Re: **High Street, Uxbridge, London – RWDI Pedestrian Level Wind Desk-Based Assessment – Ref No: 2404017- Revision B – 27th March 2024**

This document provides a detailed response to the following query received regarding the Pedestrian Level Wind Desk Based Assessment undertaken by RWDI:

Microclimate – Wind

Figure: 6

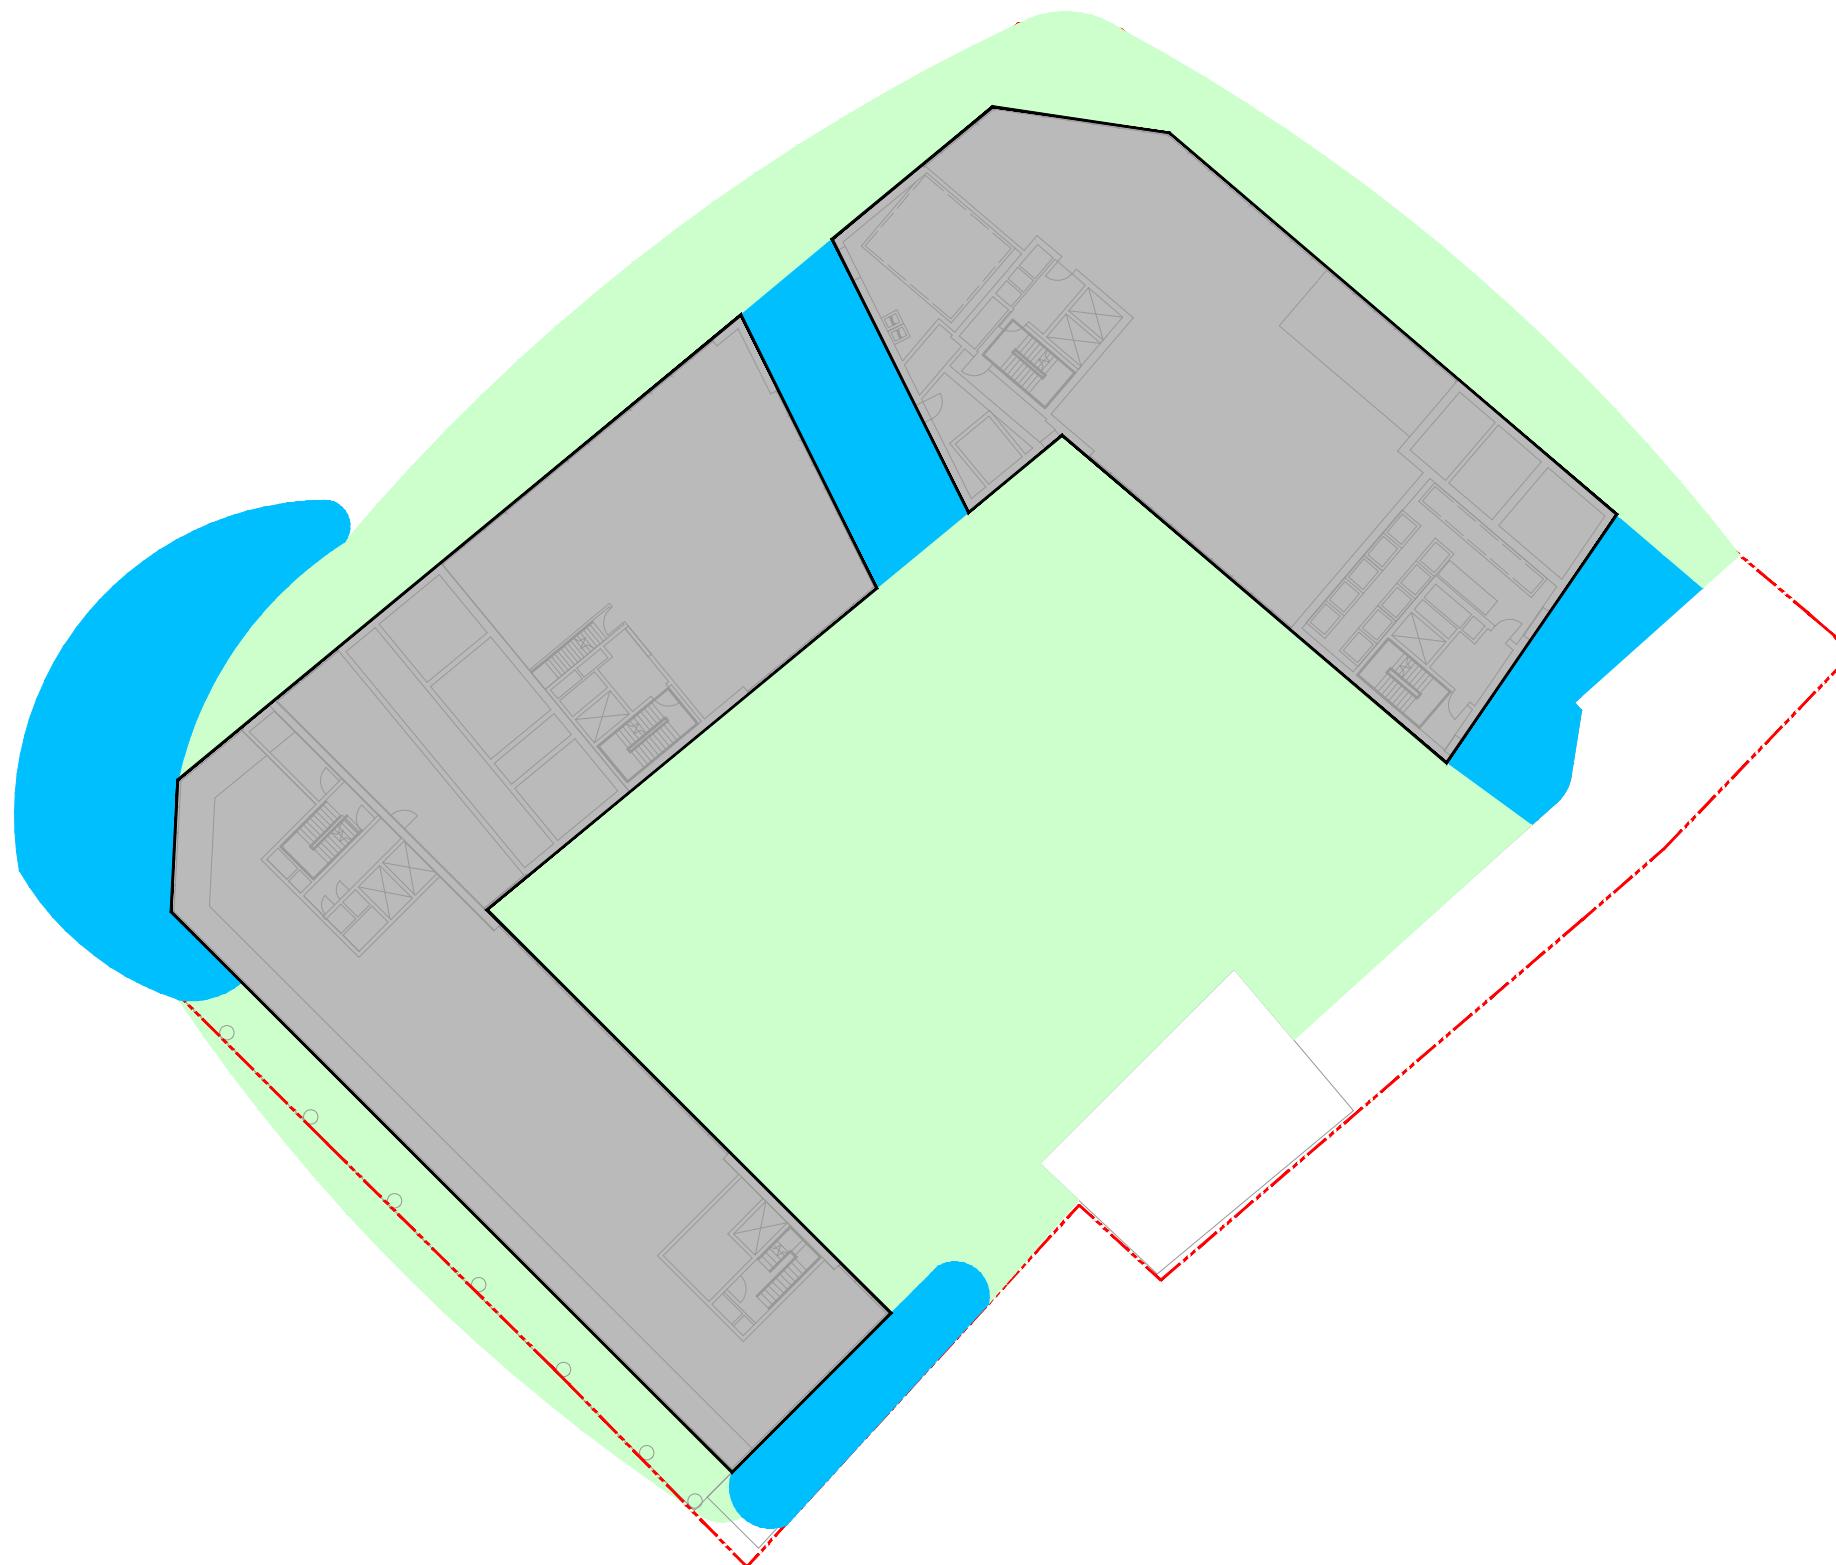
It is also concerning that the proposed rooftop amenity area is deemed unsuitable for sitting, even in the less windy summer season, despite being intended as a dwell space. Additionally, to a lesser degree, the building's corner at the high street may cause further wind discomfort, the proposed passageways could become wind tunnels, and the courtyard space appears unsuitable for sitting during the windiest seasons.

The courtyard space is expected to be suitable for 'standing' use during the windiest season and 'sitting' during the summer. These conditions are considered to be appropriate for an outdoor amenity space, for which there is a greater expectation of comfort and usability during the summer. Conditions categorised as suitable for 'standing' in the winter would still be comfortable and usable for some of the time, only less frequently than during the critical summer months (which reflects a realistically lower expectation of usability and comfort during the winter when colder temperatures and increased precipitation are the norm).
